Re: 121-129 York St./Harborview Townhouses

**TO: CITY OF PORTLAND PLANNING AUTHORITY**  
**DATE: APRIL 14, 2011**  
**RE: REPLY TO LEVEL III SITE PLAN REVIEW COMMENTS DATED**  
**APRIL 12, 2011**

Subject: 127 – 129 York St.  
Owner Applicant: Harborview Development LLC

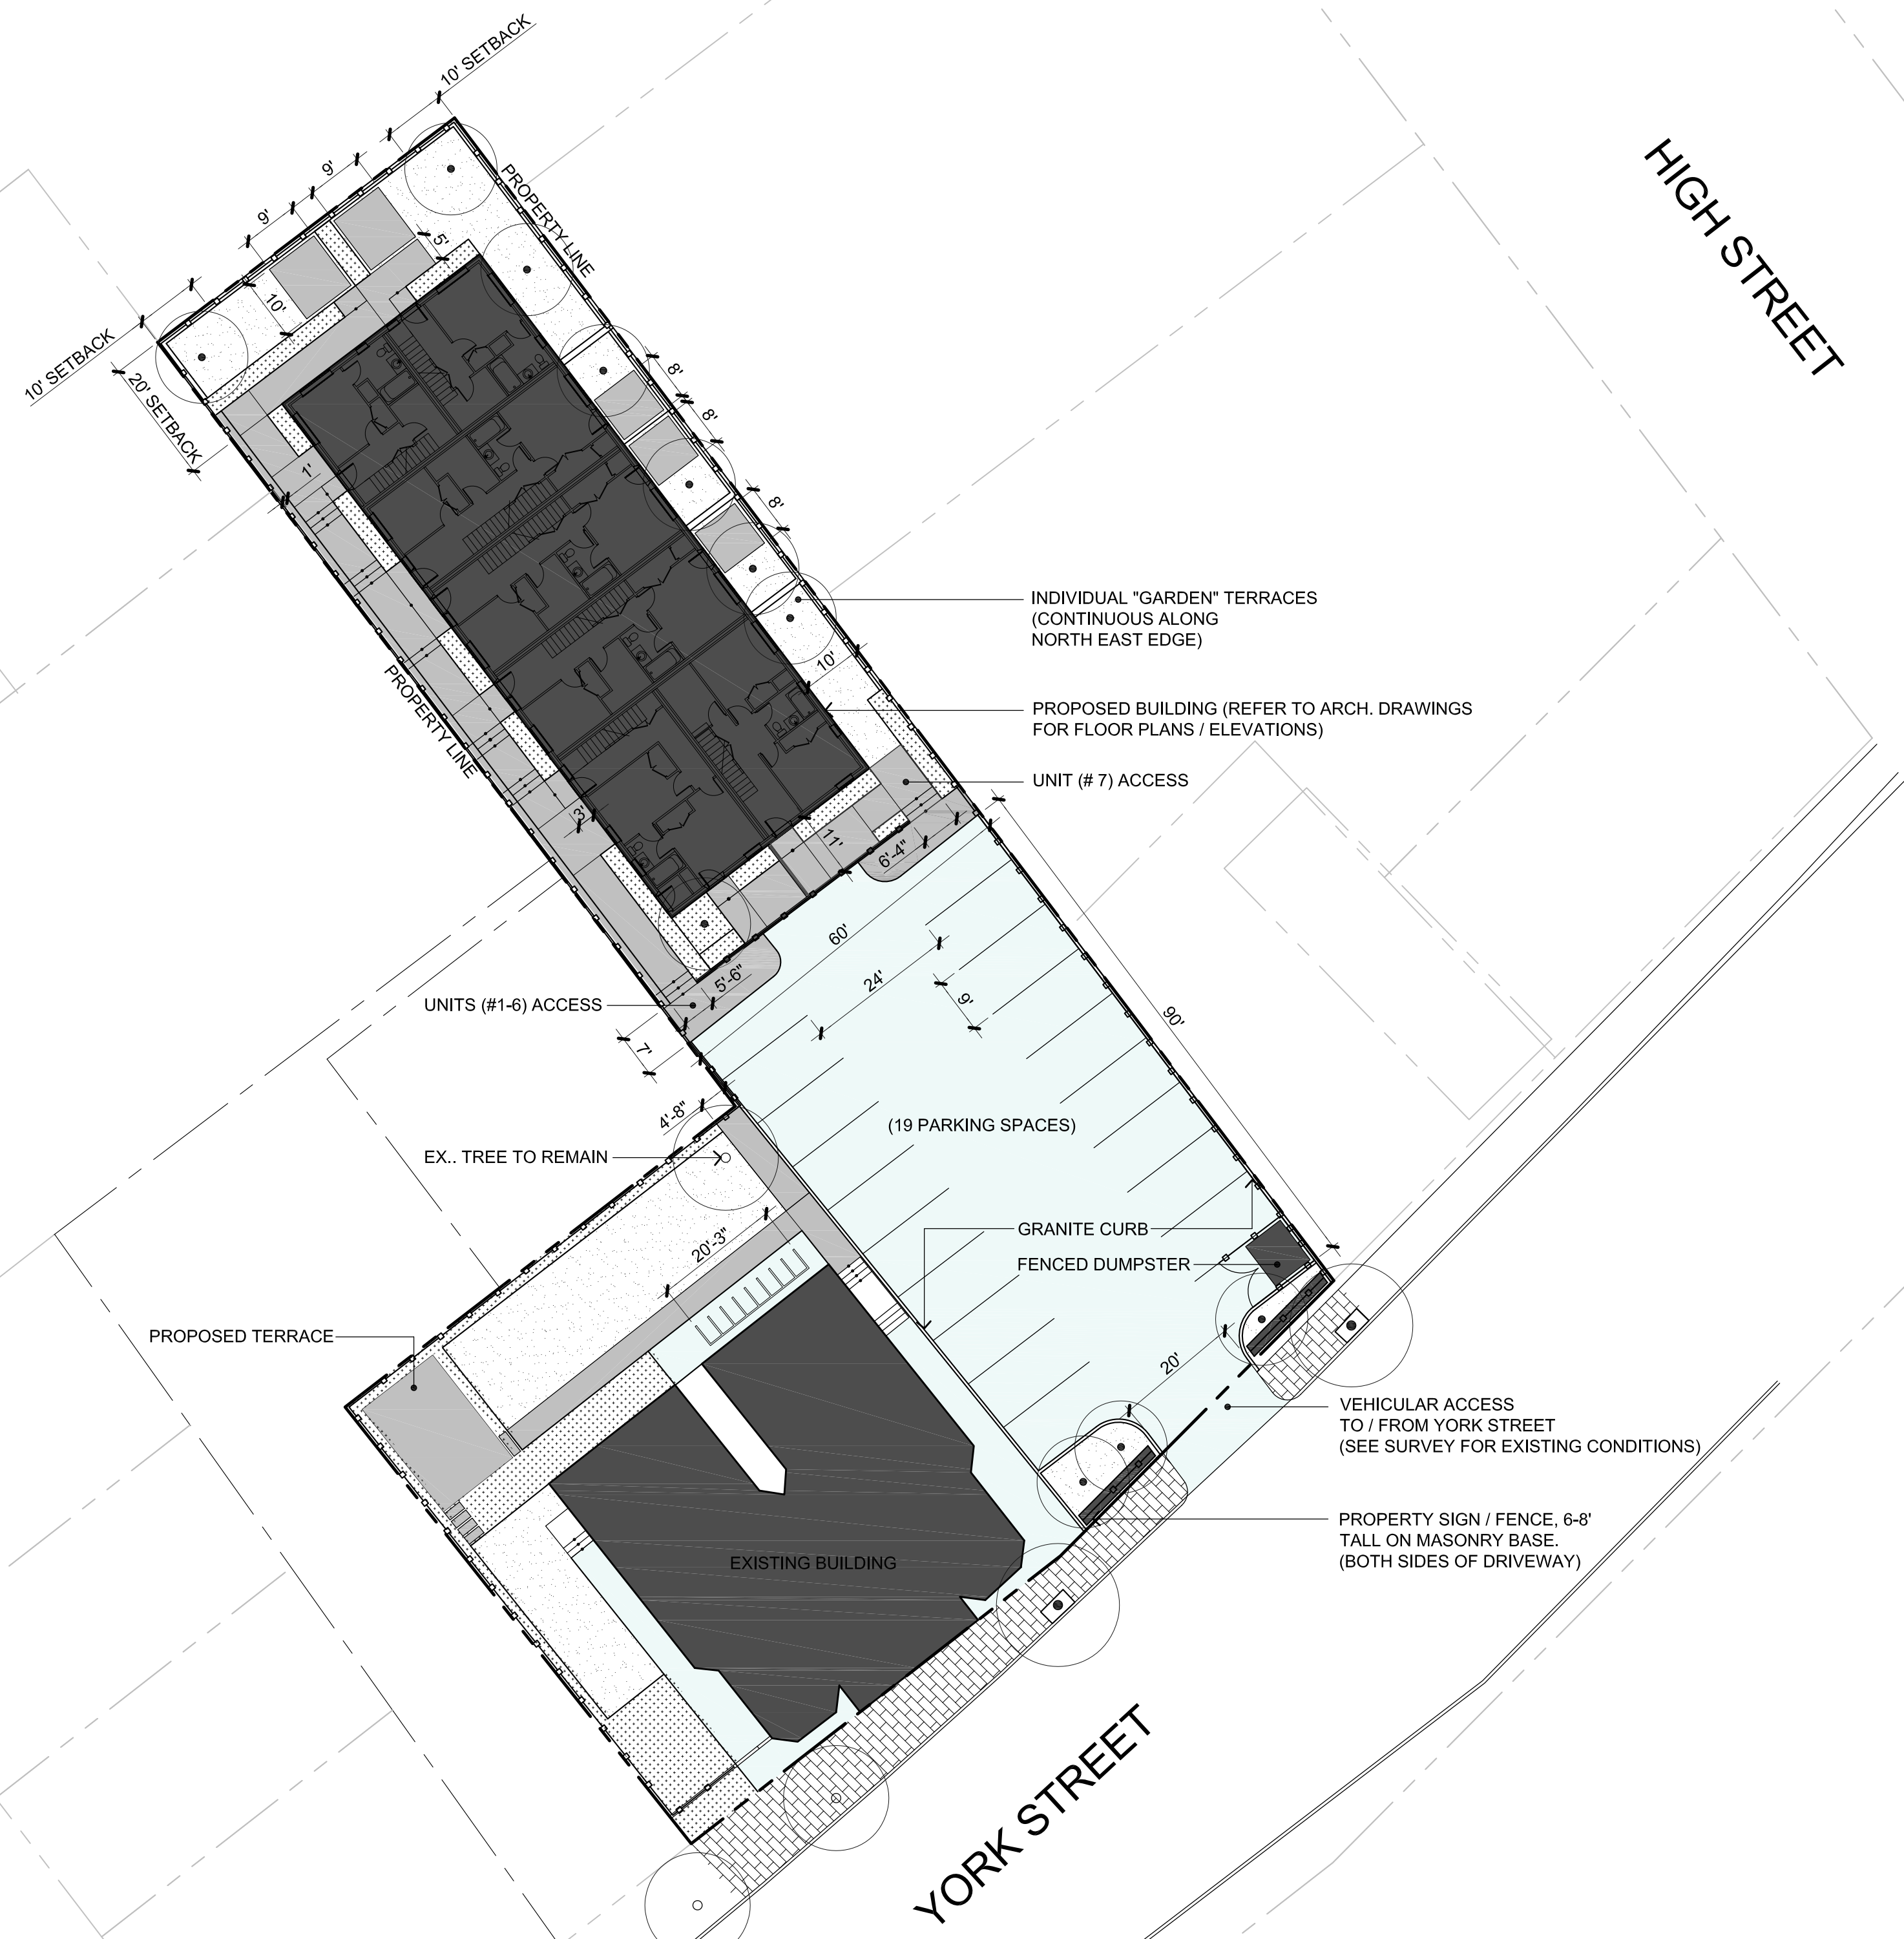
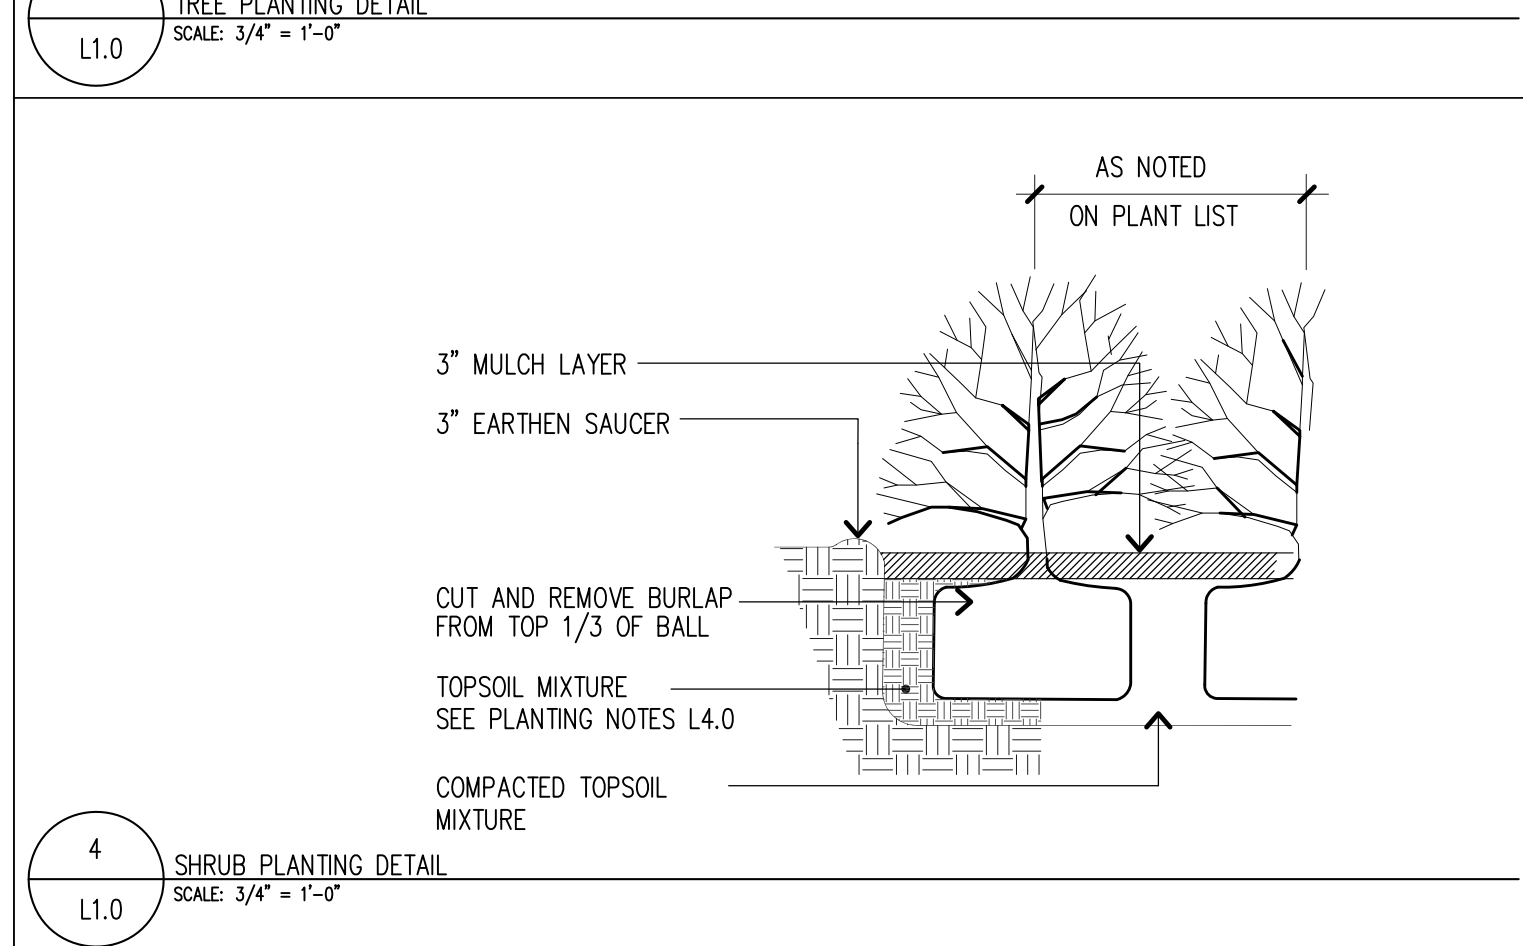
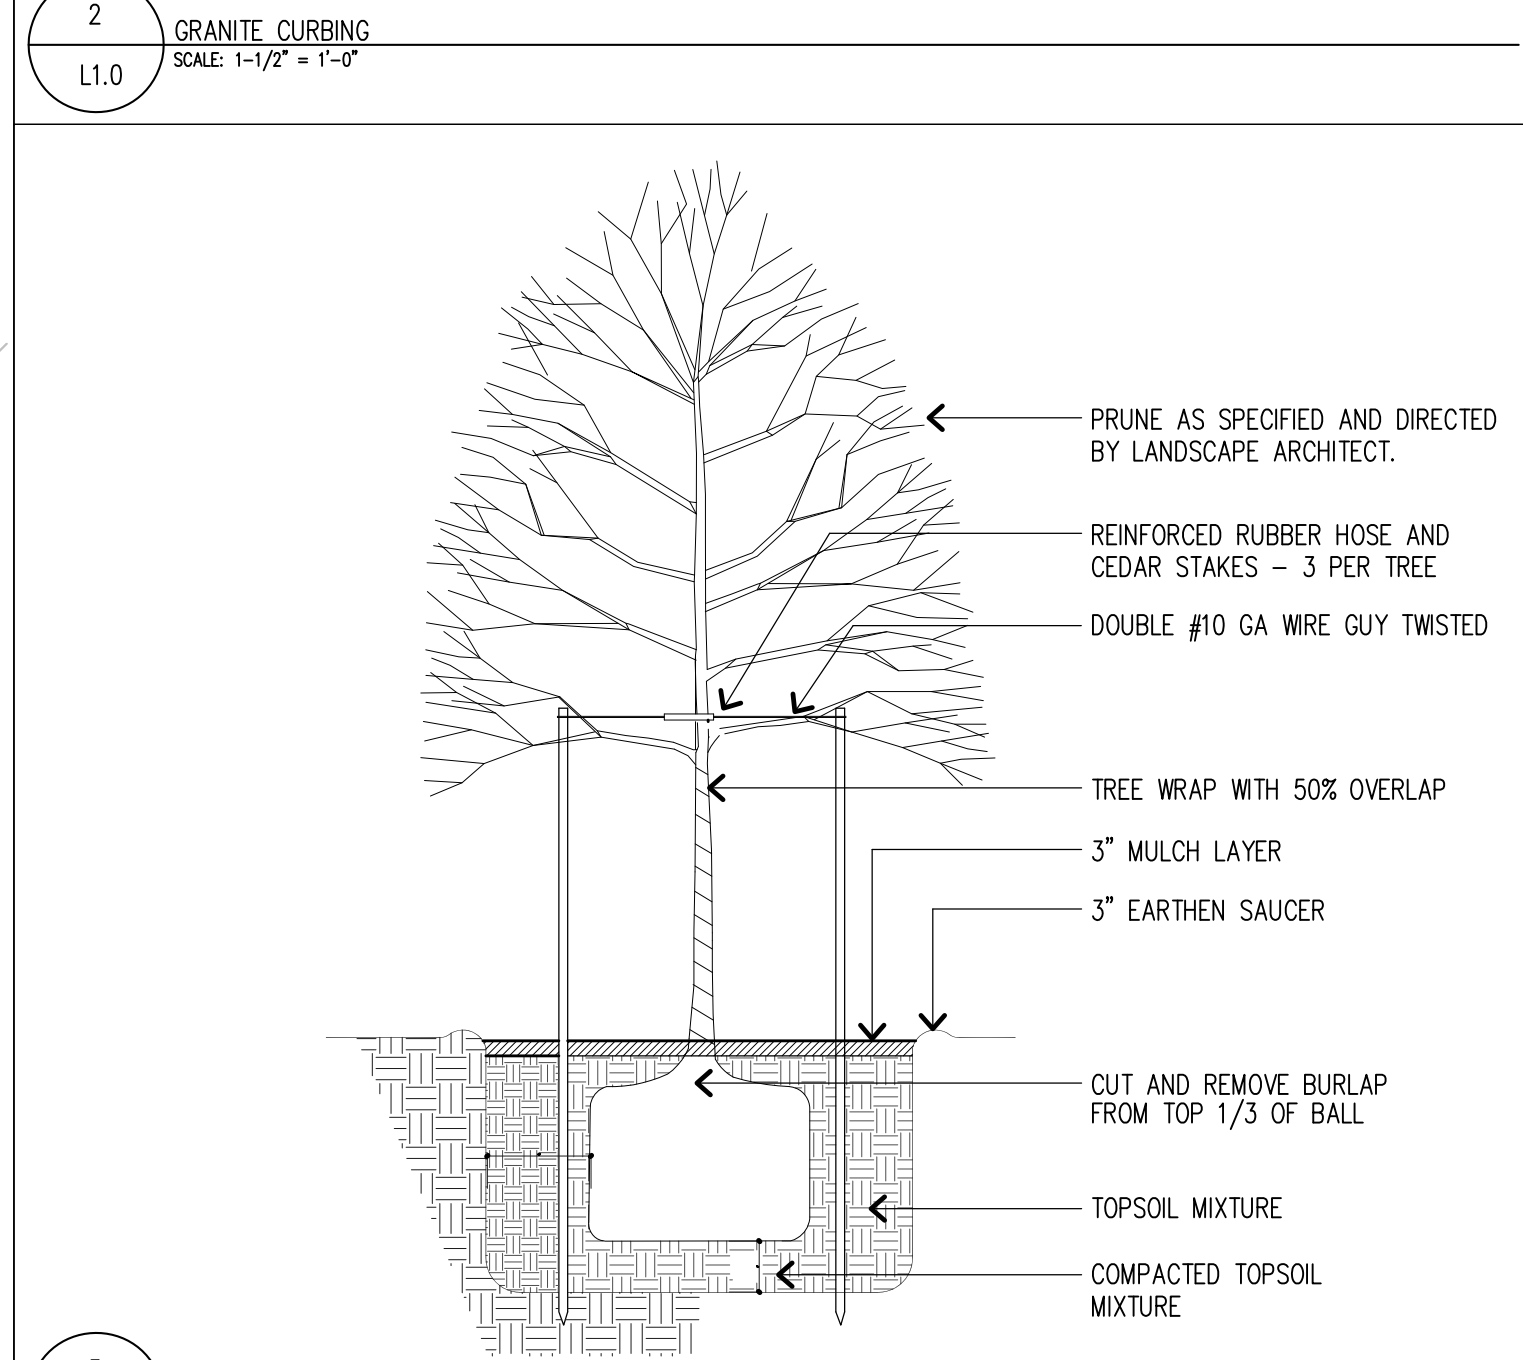
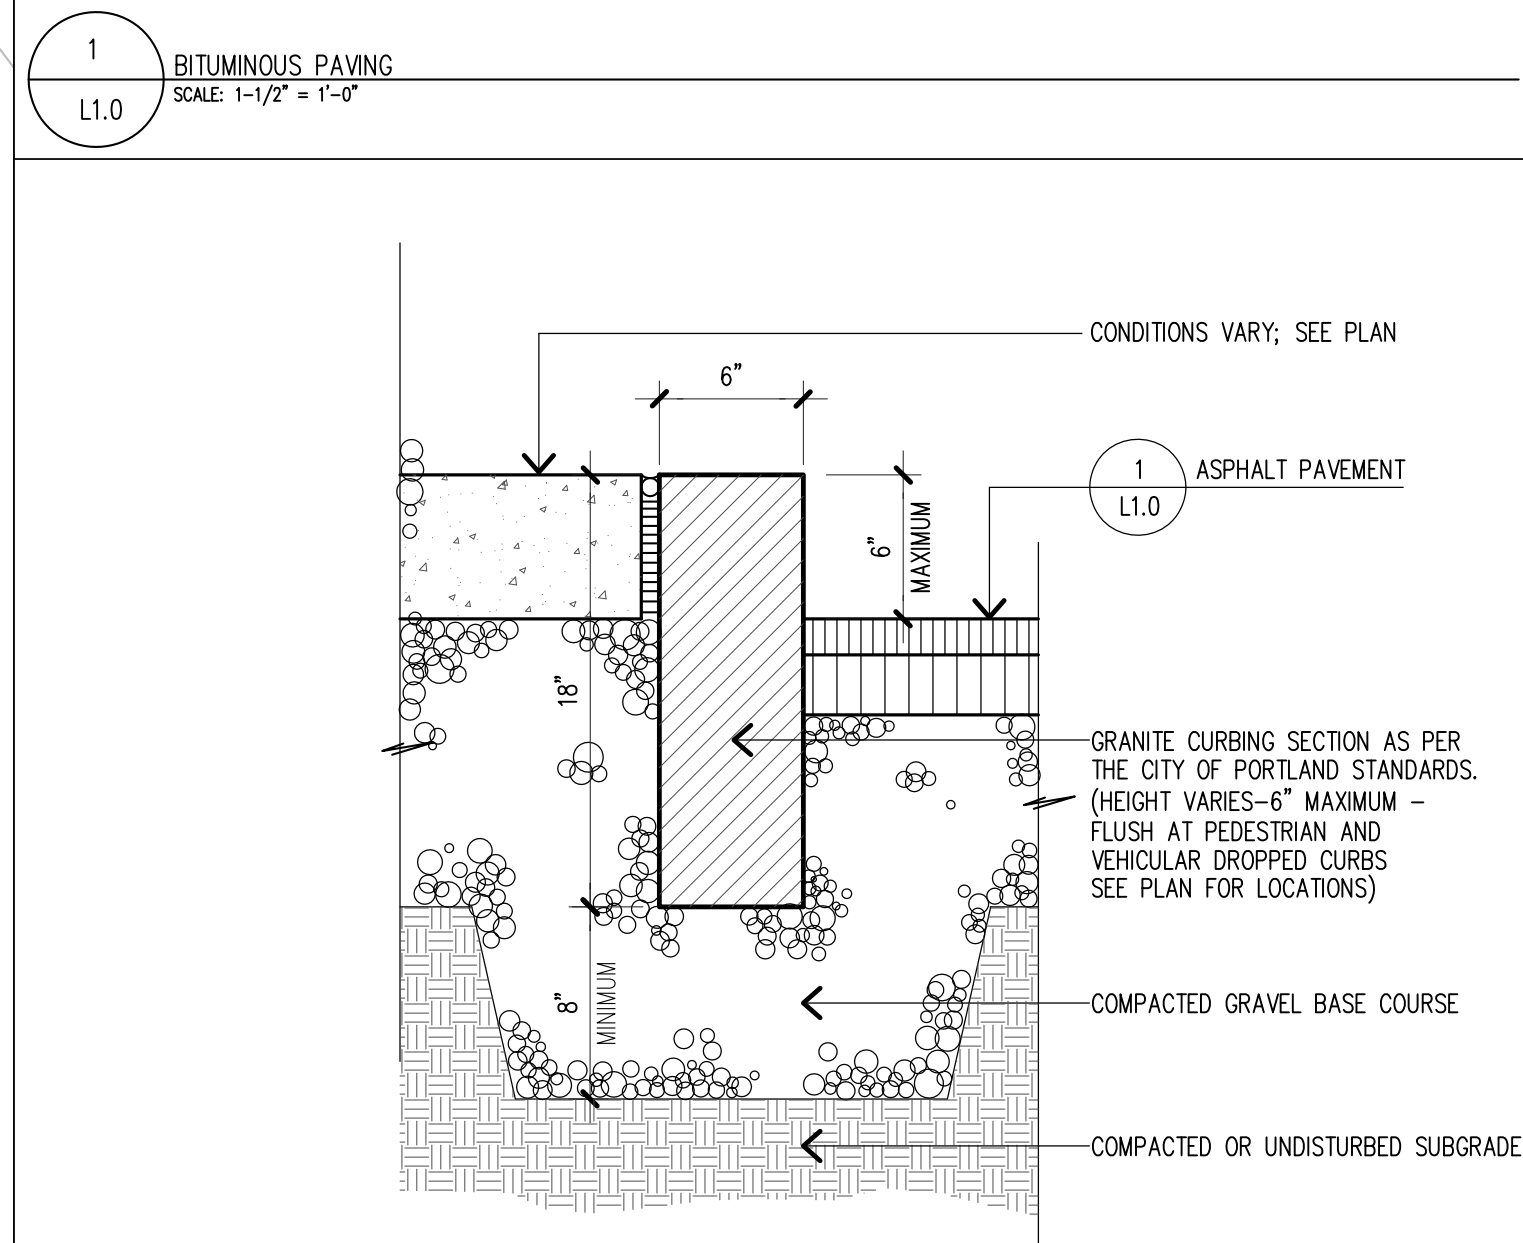
5. I am not sure that all overhangs and projections have been shown on the building site plan.

6. I am not sure what all the markings around the building refer to.

7. I am also seeing a mention on the plans that two signs on either side of the driveway would be proposed. Two signs would not be allowed and not within 5’ of the property line for site line purposes. Sign permits are a separate application, but I don’t mind reviewing the concepts at this stage.

See the revised Site Plan.

See the revised Site Plan – markings are explained in the Symbols Legend.

See the revised Site Plan. These are street fences with the property address on one of them, not signs.
